Town & Country Planning Act 1990 (as amended)
Town & Country Planning (Tree Preservation) (England) Regulations 2012

Application No: AW/315/20/T
Site Address: 28A Kingsway Aldwick PO21 4DH
Description of works: Fell 1No. Oak (T1) to ground level as being suppressed by neighbouring Maple (T2) and Holly (T3).
Fell 1No. Norway maple (T2) to ground level as being suppressed by (T1) and (T2)
Fell 1No. Holly (T3) to ground level as growing into (T1) and (T2) and as a group of trees making the garden look messy and over crowded.
Fell 3No. Pittosporum (T4) to ground level as structural issues within the tree are showing and as a group of shrubs they are getting overgrown.

Thank you for your internet representation made on 11th December 2020 which has been recorded as an objection with the comments as follows:

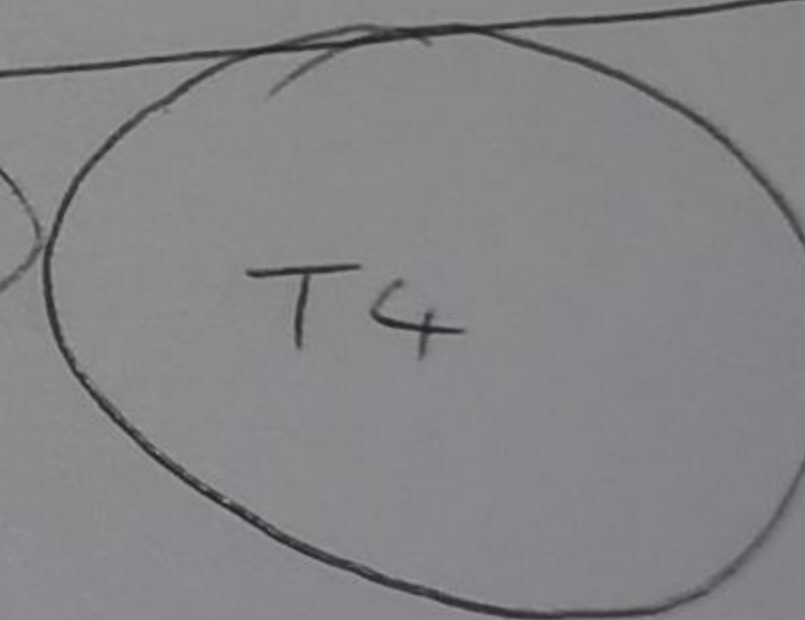
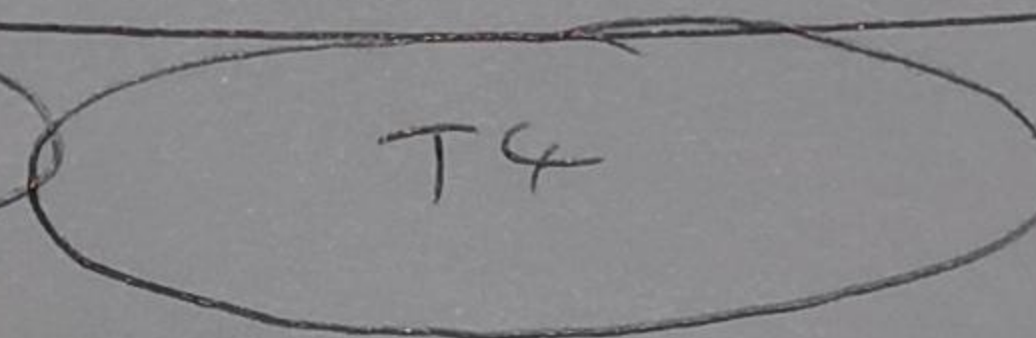
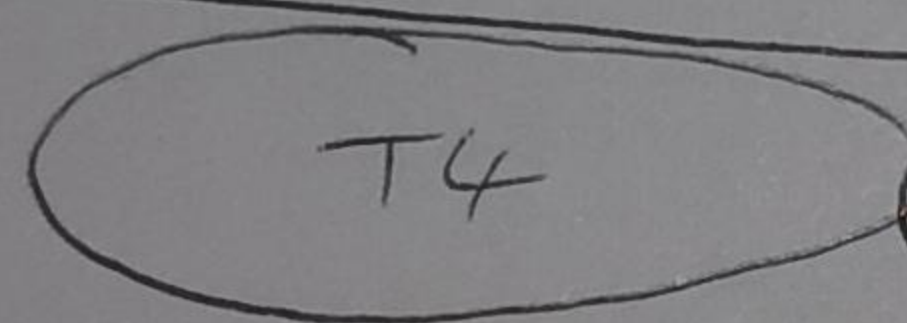
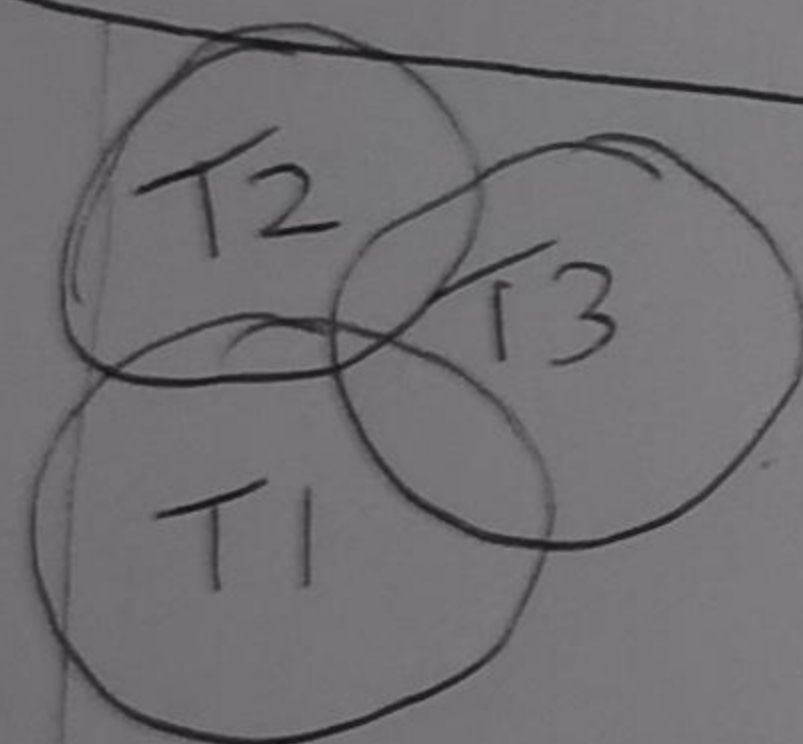
There are RPA's in place in that Application and plenty of plans identifying important trees and shrubs, facts ignored by this current tree application where a crude sketch is totally inadequate.

I strongly suggest that in order to protect this very important area of greenery, the Arun Tree Officer visits site initially to identify and label mature trees and shrubs and to visit site again to ensure the necessary steps are taken to surround the RPA's, where they must be erected/surrounded by Halo fencing as required by the permissions for AW/155/17/PL.
